**LETTER FROM FIRE RISK MANAGEMENT**

# **Memo Report**

**From:** W. Mark Cummings, P.E.  
**To:** Mr. Bo Kennedy, Fay, Spofford, & Thorndike  
**Subject:** **Fire & Life Safety Protection Review of the Proposed New Food Service Building - “The Point” at Thompson’s Point**

1. “The Point” at The Forefront at Thompson’s Point Interim Layout and Grading Plan; Dwg C-1, (draft) dated March 2015.

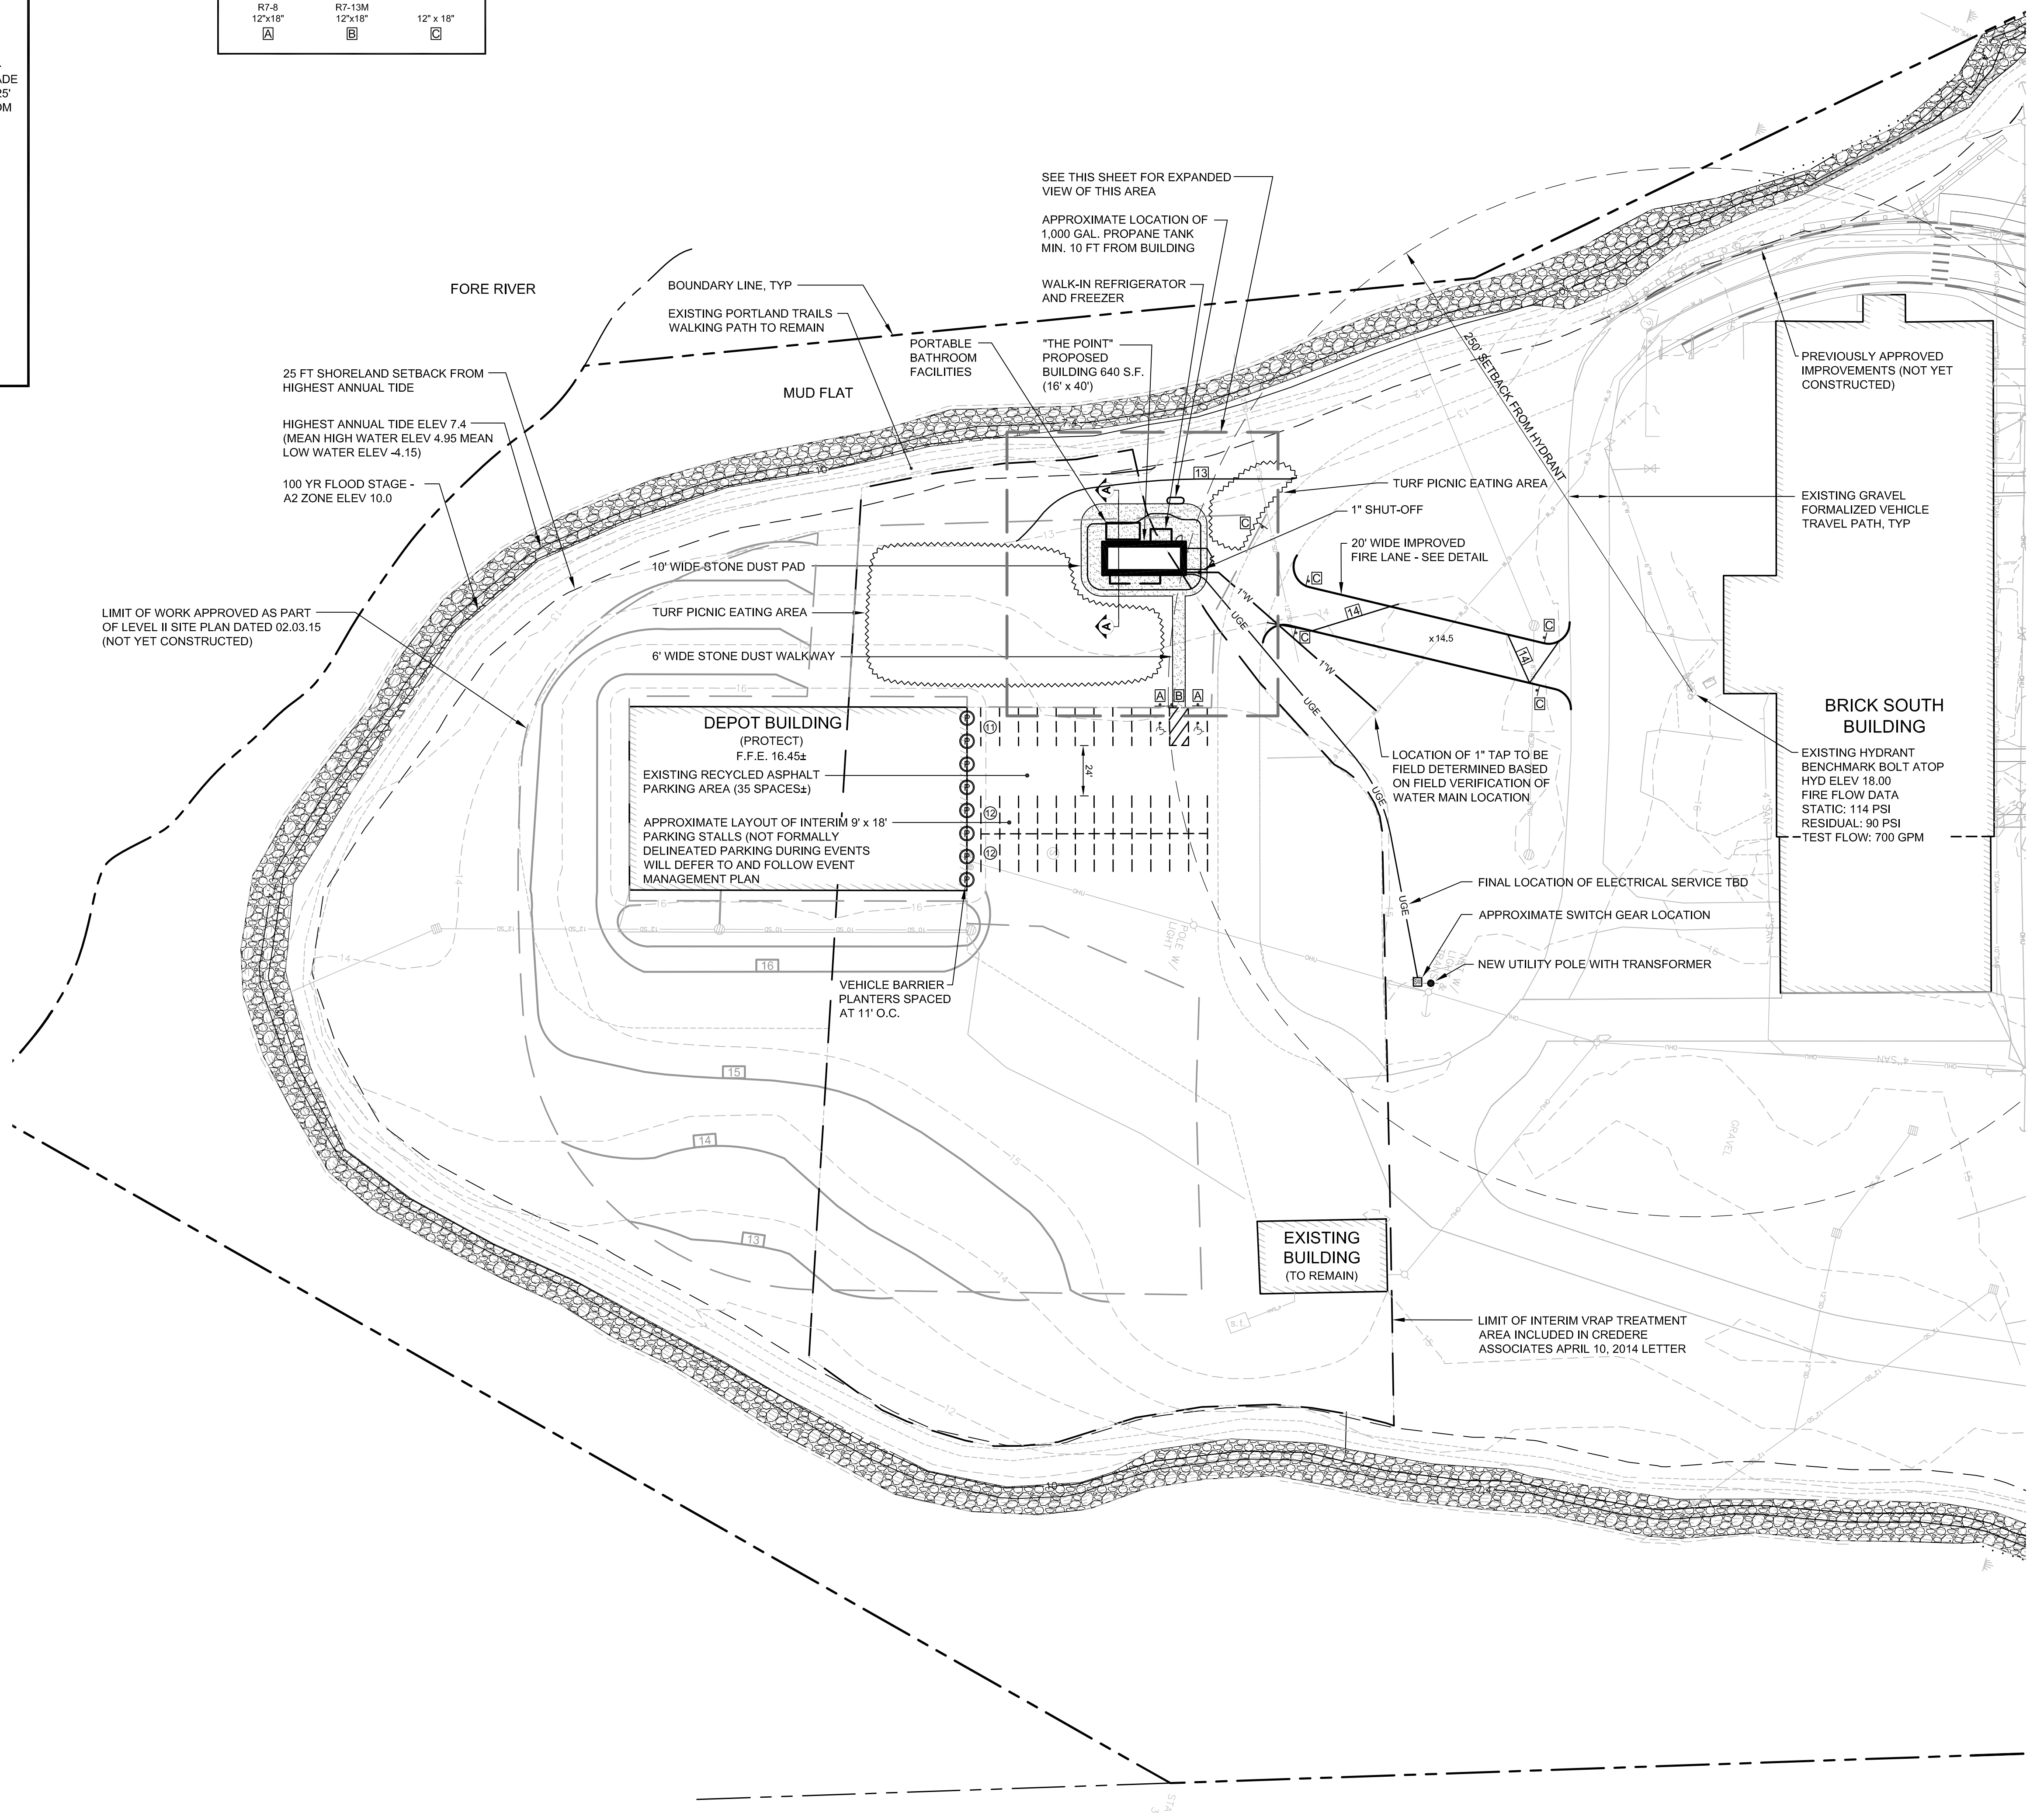
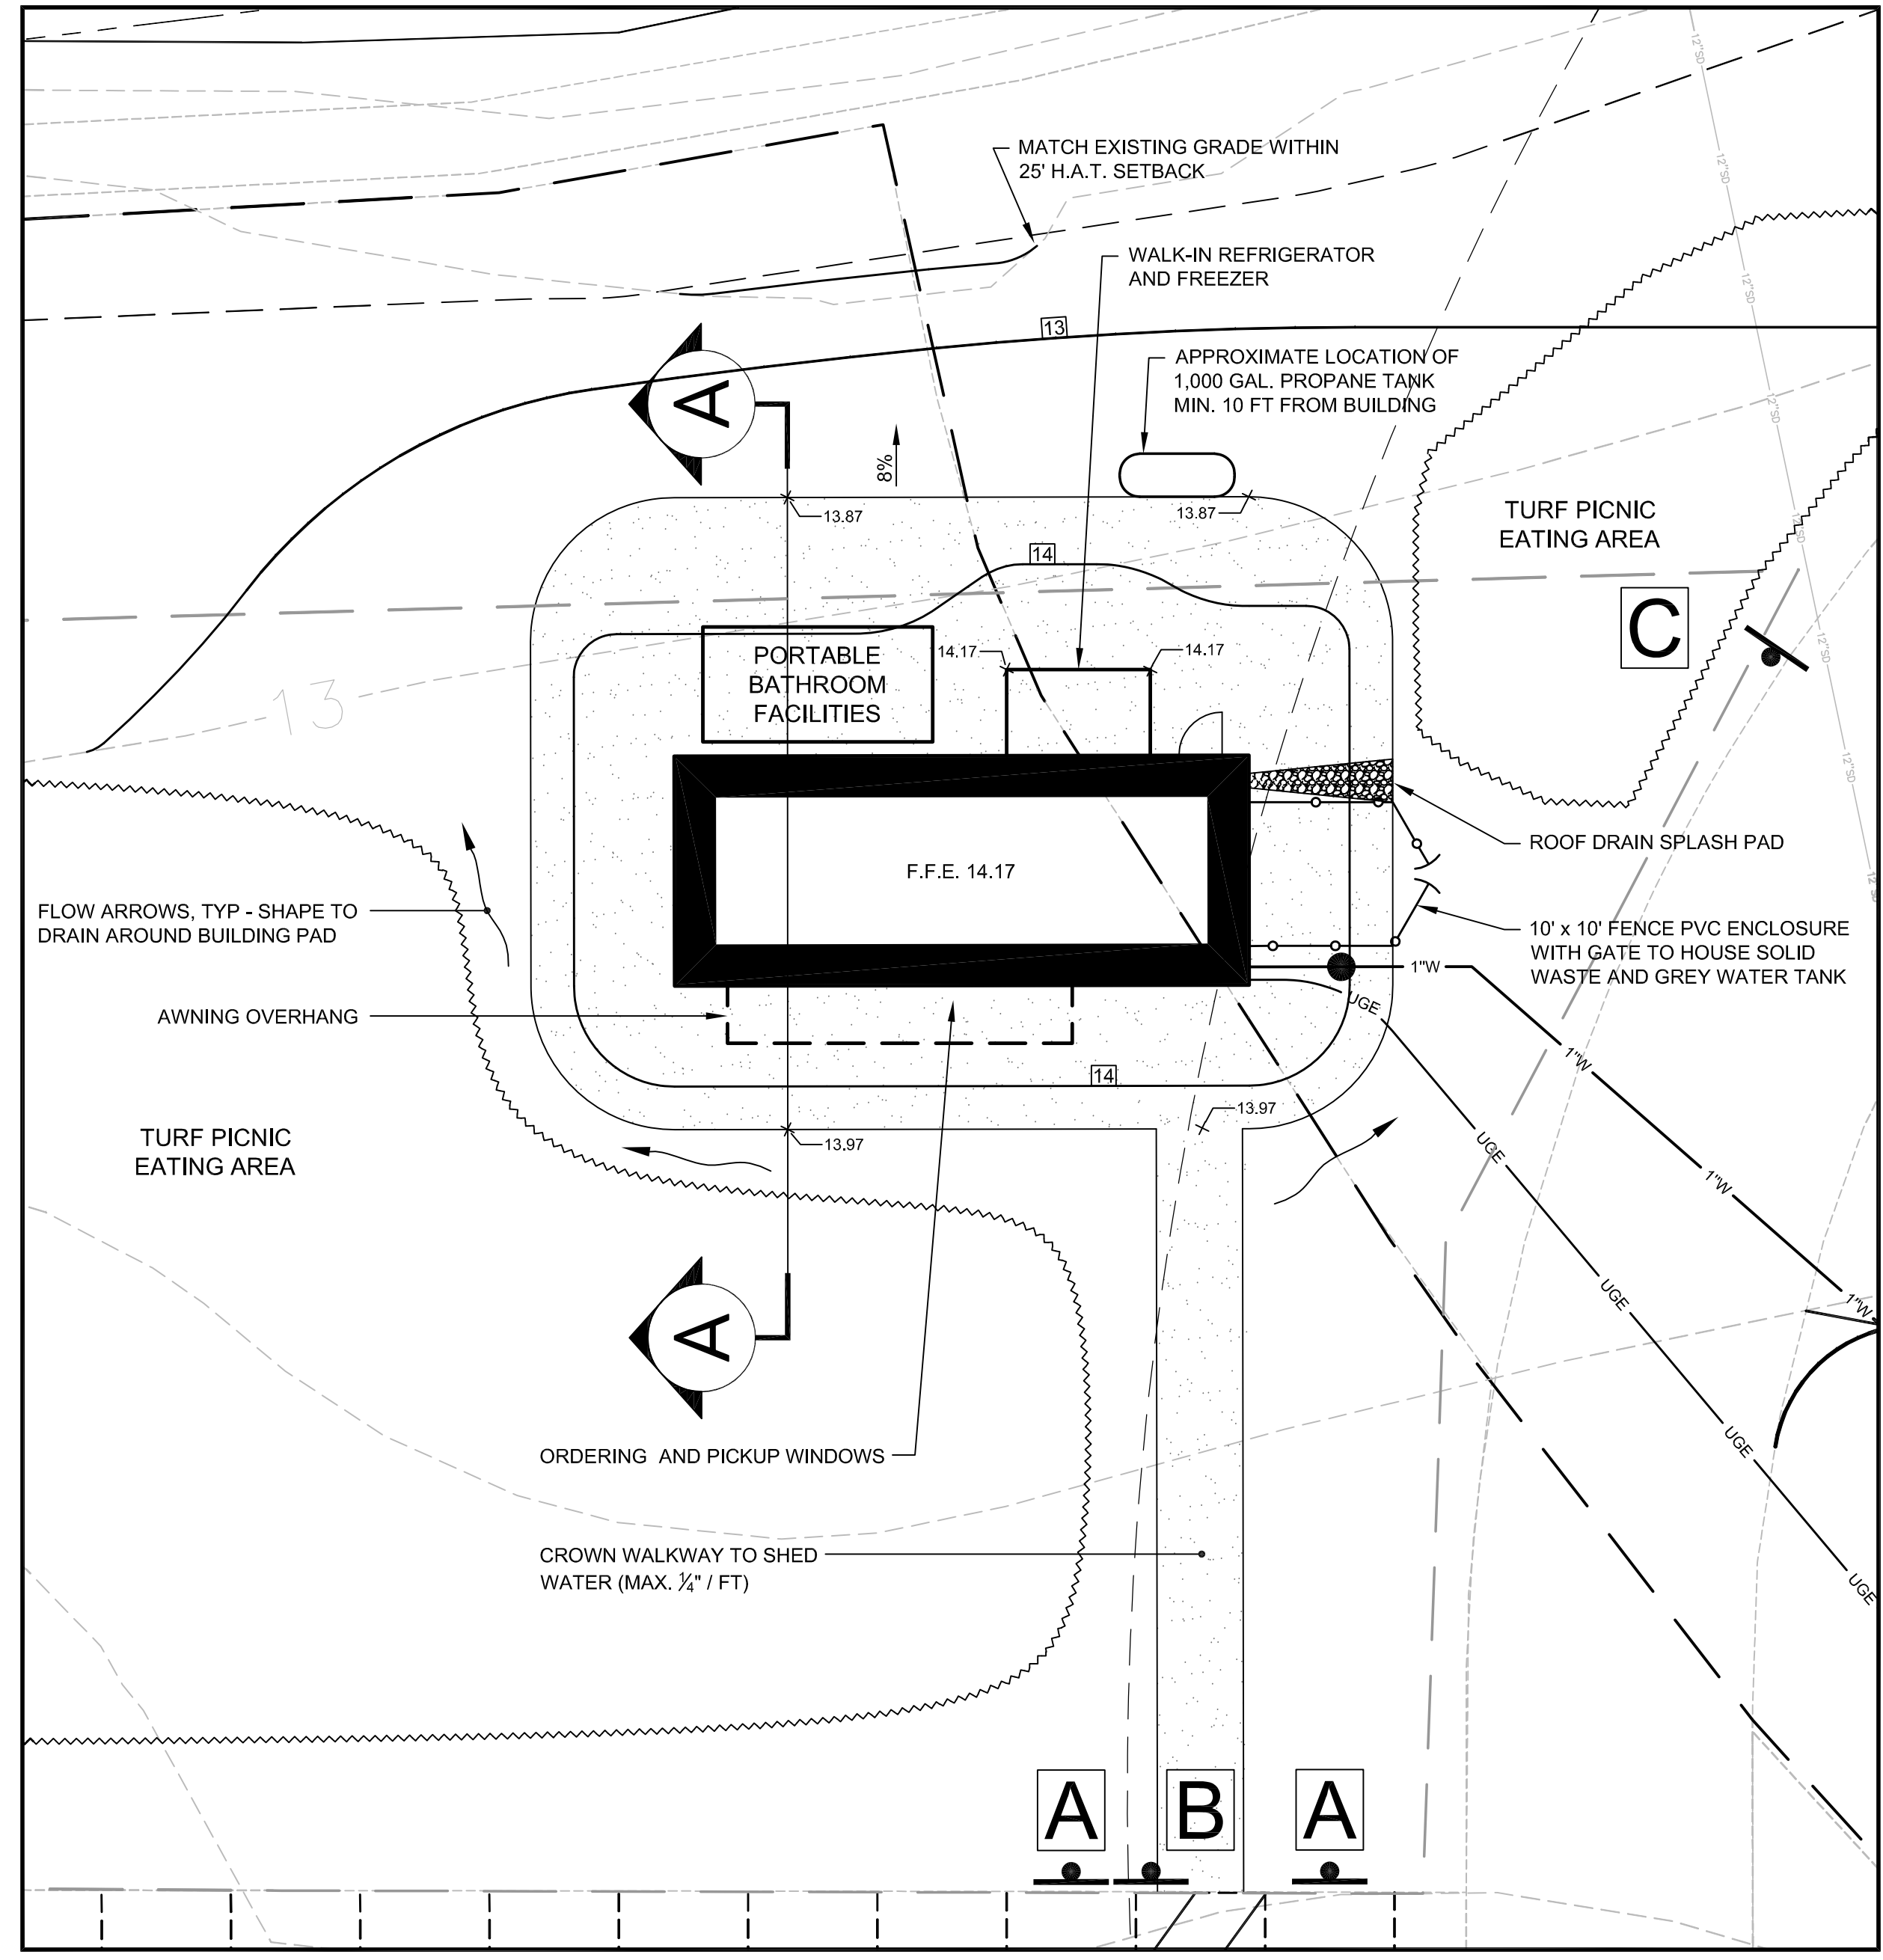
If it is required to provide a propane storage tank to support cooking operations, the storage tank must be separated from the building itself. If a single storage tank is used; as long that the capacity of the tank does not exceed 1200 gallons (water volume), it may be located such that the minimum separation from the building is 10 ft. If the size of the tank is greater than 1200 gallons, or multiple storage tanks are used that result in a capacity of more than 500 gallons, the minimum separation distance must be at least 25 ft. If the storage capacity exceeds 2000 gallons, the minimum separation distance must be at least 50 ft. Based on the proposed layout of the facility, it is recommended that any propane storage tank(s) be located on the northwest side/corner of the building; opposite to where the public will be accessing the service/pick-up windows and within easy access for emergency responders.

As evaluated in an earlier assessment of the entire Thompson's Point site, the total fire flow demand for this site as outlined in NFPA 1 (Annex E) allows for a maximum spacing of up to 500 ft between hydrants, as measured along the fire department access road(s). As a result, a hydrant should be within no more than 250 ft of the building site, measured along the travel route for fire apparatus; either by a street or fire lane. The nearest hydrant to the location of The Point is located midway along the south side of the Brick South building. The proposed site plan for The Point includes the addition of a fire access lane that connects the access road that is adjacent to The Point to the access road that runs along the south side of the Brick South building; connecting at a point that is immediately adjacent to the existing hydrant. With the addition of this fire access lane, The Point building site will be within 250 ft of a fire hydrant; meeting the requirements of NFPA 1.

NFPA 1 requires that any portion of a building, or the exterior walls of the building, can be no more than 150 ft from an access road when the facility is not protected by an automatic sprinkler system. Based on a review of the site plan, it appears that this requirement will easily be met. In addition to this requirement, NFPA 1 also requires that at least one exterior door for the building be within 50 ft. of an access roadway. The drawings provided for this review did not provide a level of detail that included the building's exterior doorway locations; albeit based on the locations of the roadways and parking lots depicted on the Site Plan, it appears that this requirement can be easily accommodated.

Chapter 10 of the Portland City Ordinances has a requirement that, where available, the fire department vehicles should have access to at least two (2) sides of each building. Based on the site plan provided for this building, it will be possible to access this building from at least two sides. Although both NFPA 1 and the City's regulations include requirements regarding "dead-end" access roads, these requirements do not apply to this situation.
